September 27, 2018

RE: **Lot 1 Block 9 Unit 22 Volcano Cliffs SAD 228**
6444 Picardia NW
Grading and Drainage Plan
Engineers Stamp Date 8/18/18 (D10D003Q01)

James D Hughes, P.E.
Principal Engineer, Hydrology
Planning Department

| DAVID SOULE NEW MEXICO 14522 REGISTERED PROFESSIONAL ENGINEER | GRADING AND DRAINAGE PLAN | DATE 8-17-18 |

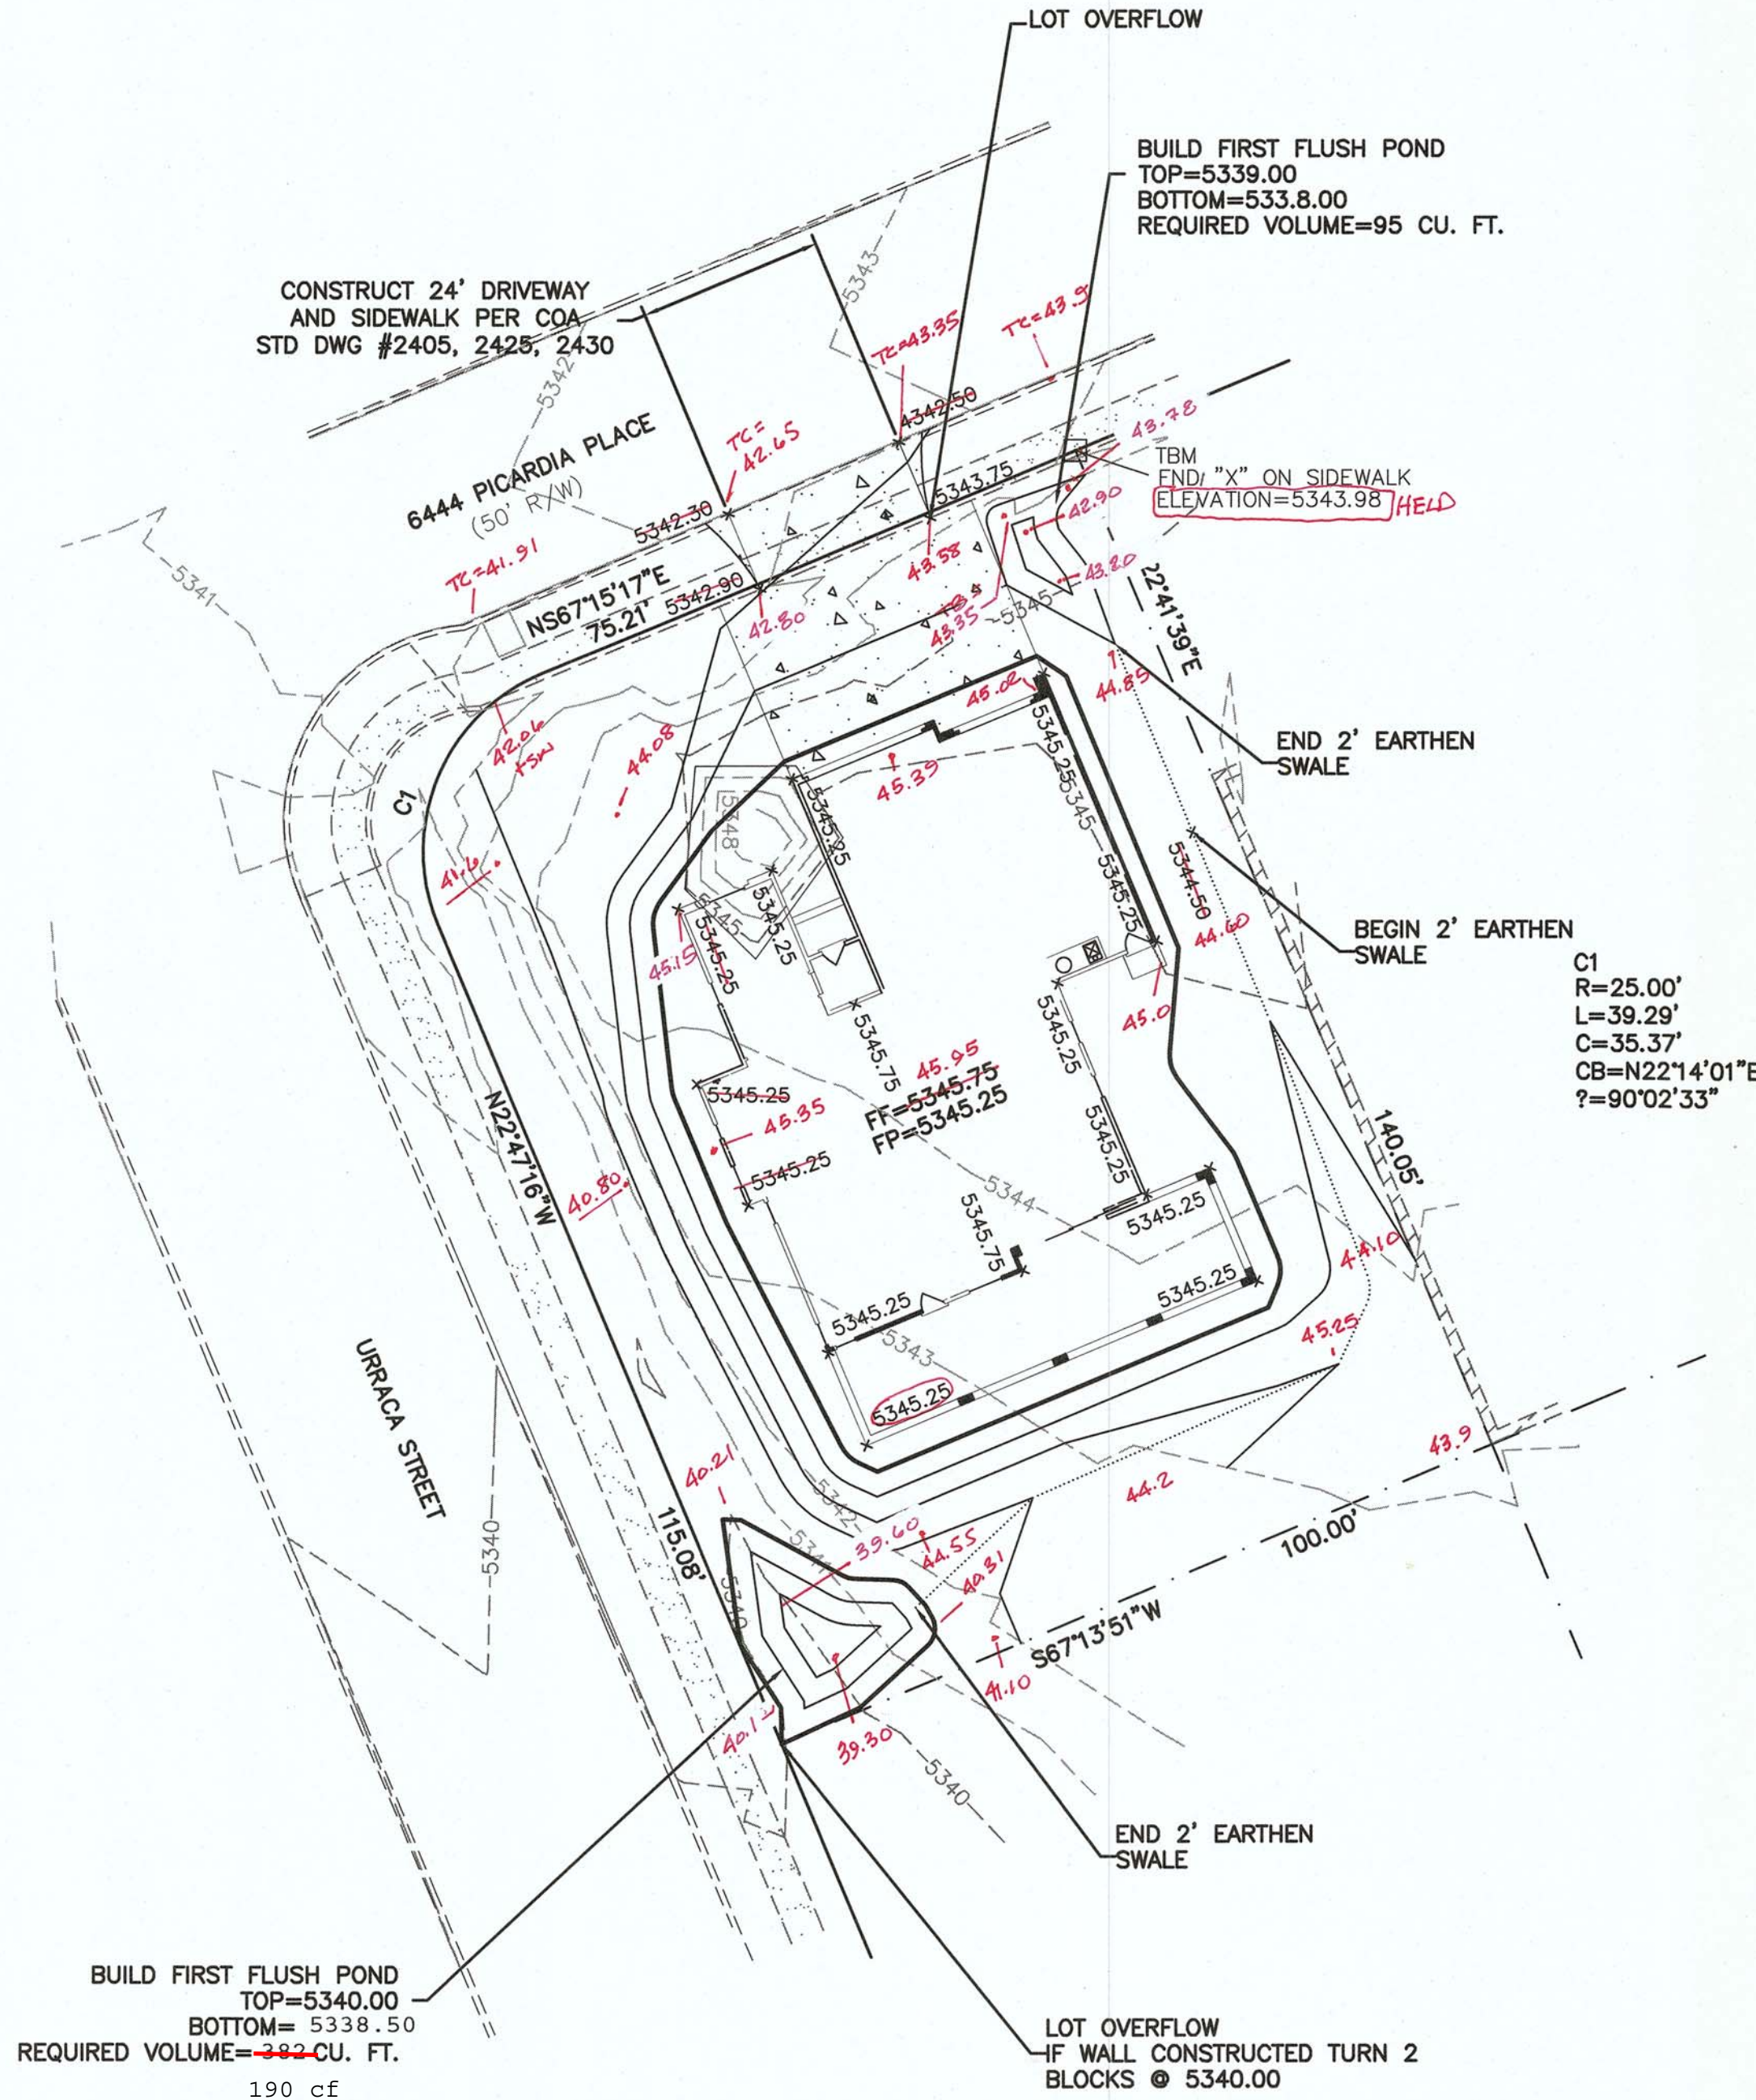
- Remove the dirt from the street being used as a ramp.
- Remove dirt piles on the sidewalk.
